Permit Inspections Harnett County

Permit Number: BRES2105-0025

Description: **44x16 double decker Deck**

Site Address: **573 COACHMAN WAY**

Facing House

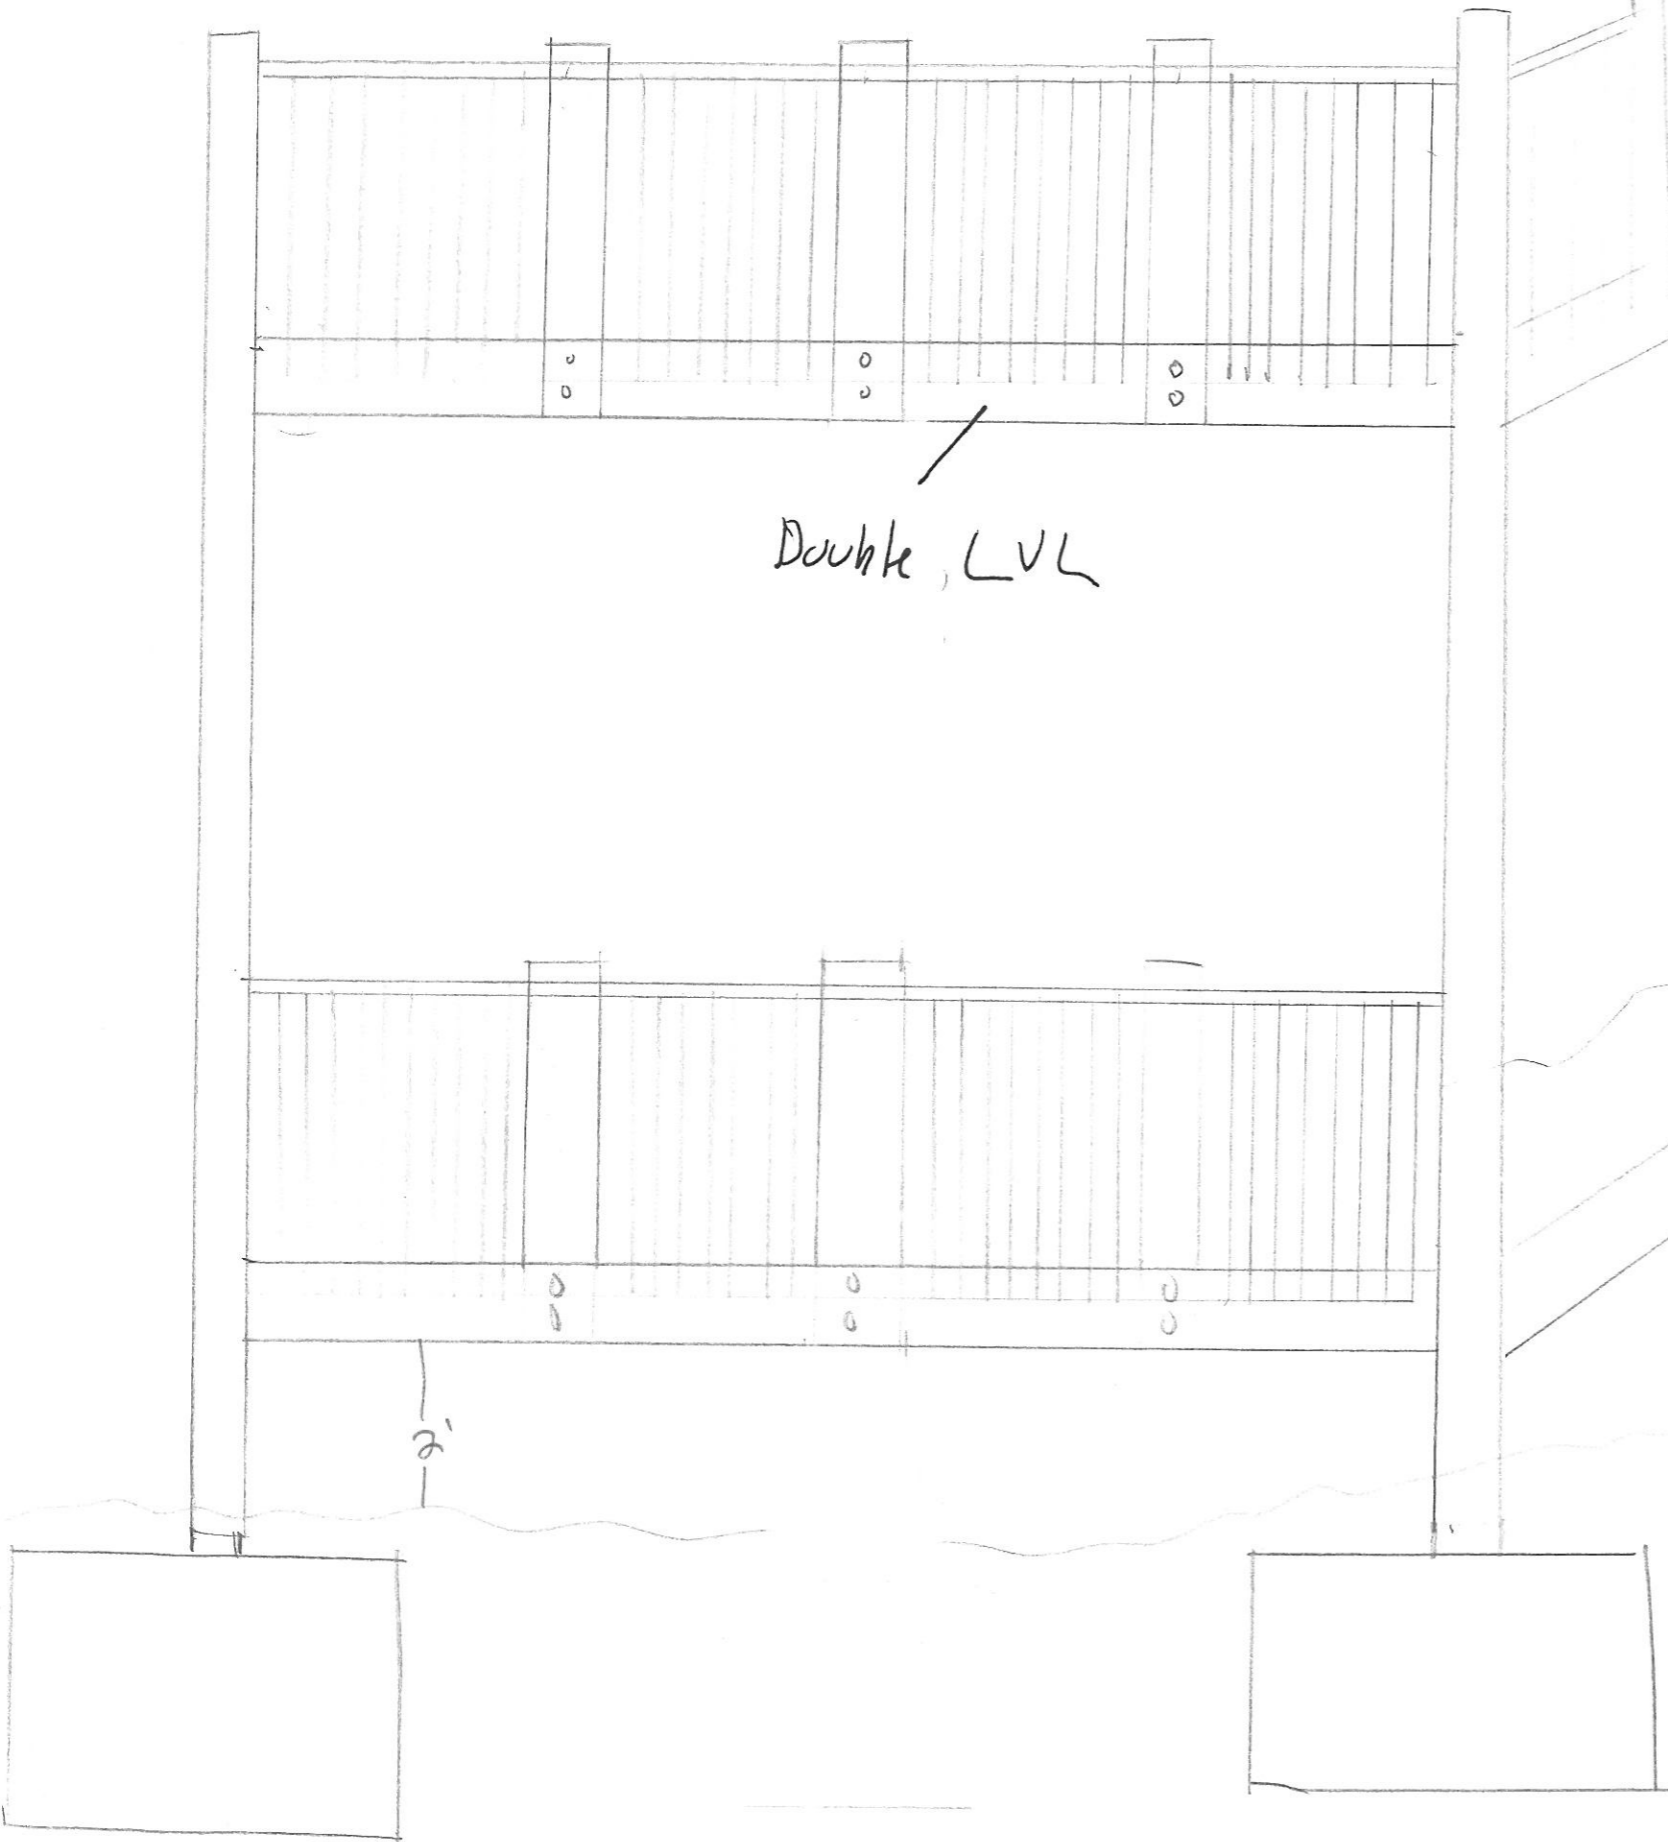
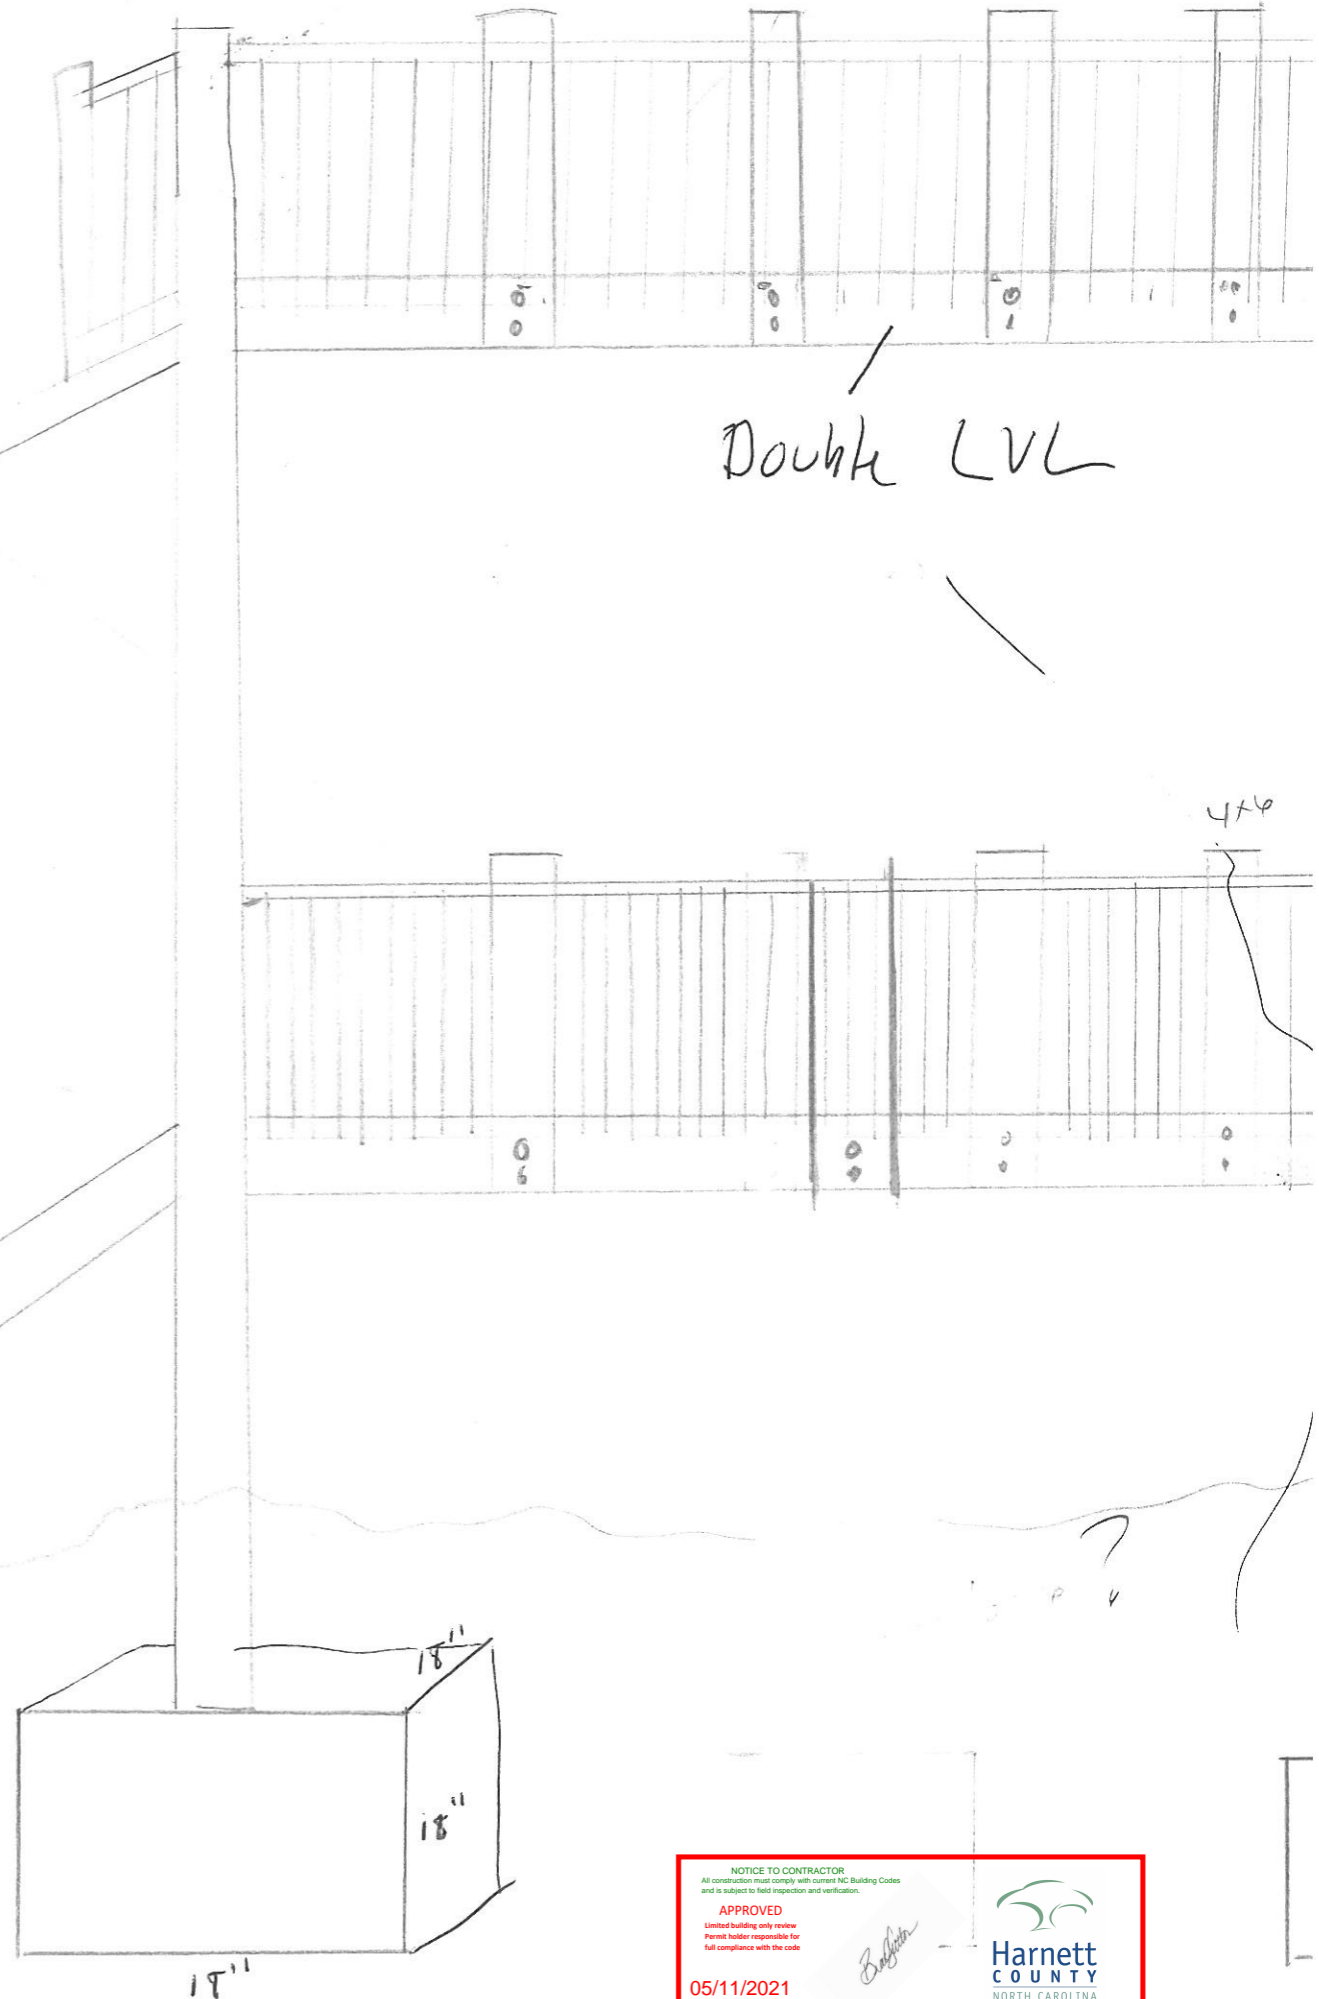
SEQ ID	SCHEDULED DATE	COMPLETED DATE	TYPE	INSPECTOR	RESULT	REMARKS
			OPEN FLOOR	Slade Burton Lawson III		
Notes:						
			ROUGH IN	Slade Burton Lawson III		
Notes:						
			FINAL**	Slade Burton Lawson III		eTRAKiT Inspection Request
Notes:						
	6/1/2021	6/1/2021	FOOTING	Slade Burton Lawson III	APPROVED	
Notes: Inspector SBL changed the inspection assignment from SBL to SPG spg changed Inspection Date/Time from 05/28/2021 to 06/01/2021						
	12/10/2021	12/10/2021	FINAL**	Steven Gazlay	DISAPPROVED	eTRAKiT Inspection Request
Notes: 12/9/2021 12:52 PM George Nilsen Contact Name: George Nilsen Site Address: 573 COACHMAN WAY Phone: 9199352827 e-Mail: gviper.nilsen2@gmail.com Inspector SBL changed the inspection assignment from SBL to SPG Provide lvl documentation. Handrails must be 34-38 measured at walkline. Provide engineering letter on over span girders and girder splice not bearing on posts, joists exceeding span, girders not supported on posts. Need 3 nails in ledger strip at joist location. Bottom steps cannot exceed the height of steps above.
